Application No: BR/63/22/PL
Site Address: Salisbury House The Steyne Bognor Regis PO21 1TX
Description of works: Change of use of 5 No self-contained flats for adults with learning difficulties to 5 No self-contained flats and formation of 5 No further flats from HMO rooms, garage and office, repairs and decoration of external surfaces, minor alterations to elevation facing Sadler Street, change one window facing rear courtyard to French doors & apply obscure film to 2 windows in courtyard area. This application affects the setting of listed buildings, affects the character & appearance of The Steyne Conservation Area and is in CIL Zone 4 (Zero Rated) as flats.

Thank you for your internet representation made on 20th June 2022 which has been recorded as an objection with the comments as follows:

GROUND FLOOR

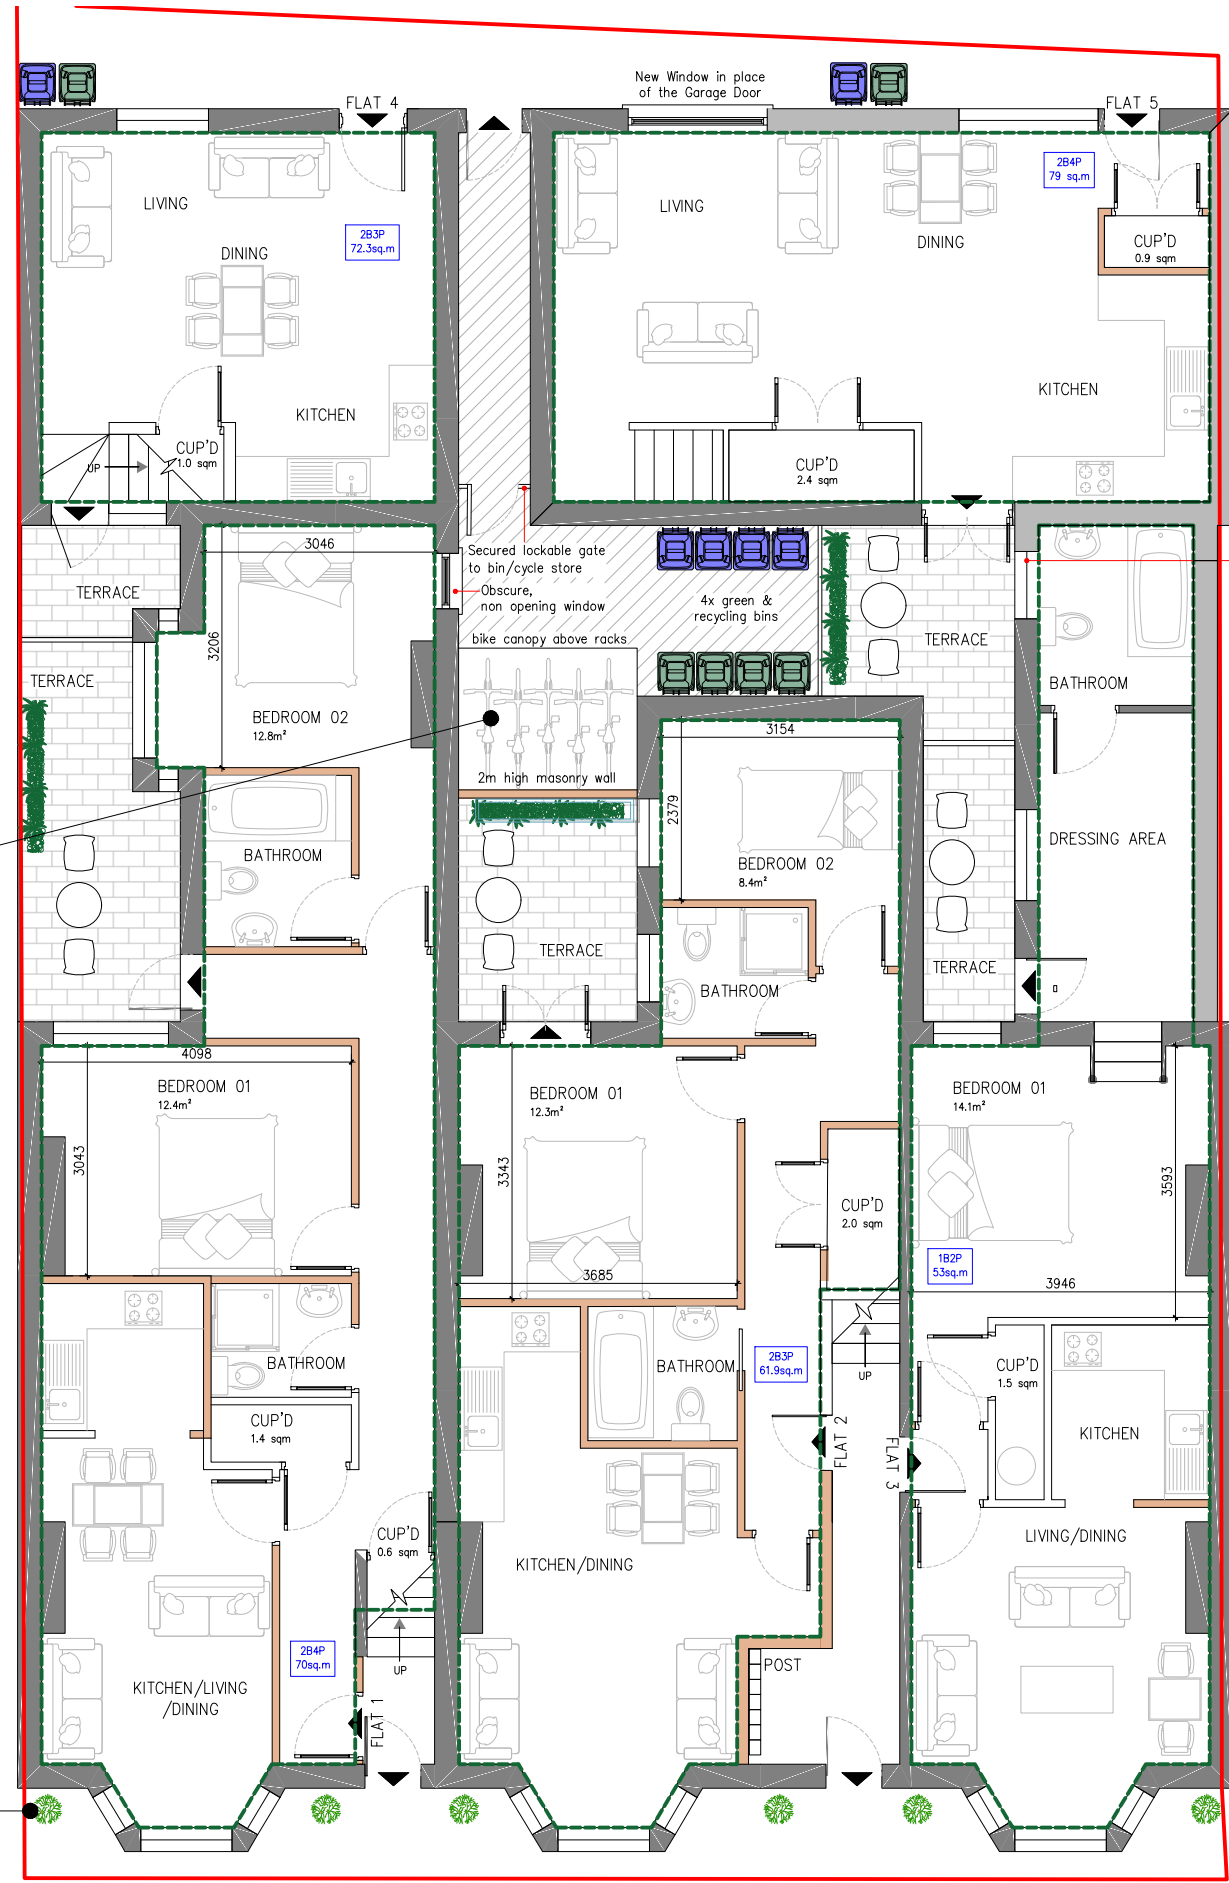
No provisions are being made for bin storage and refuse
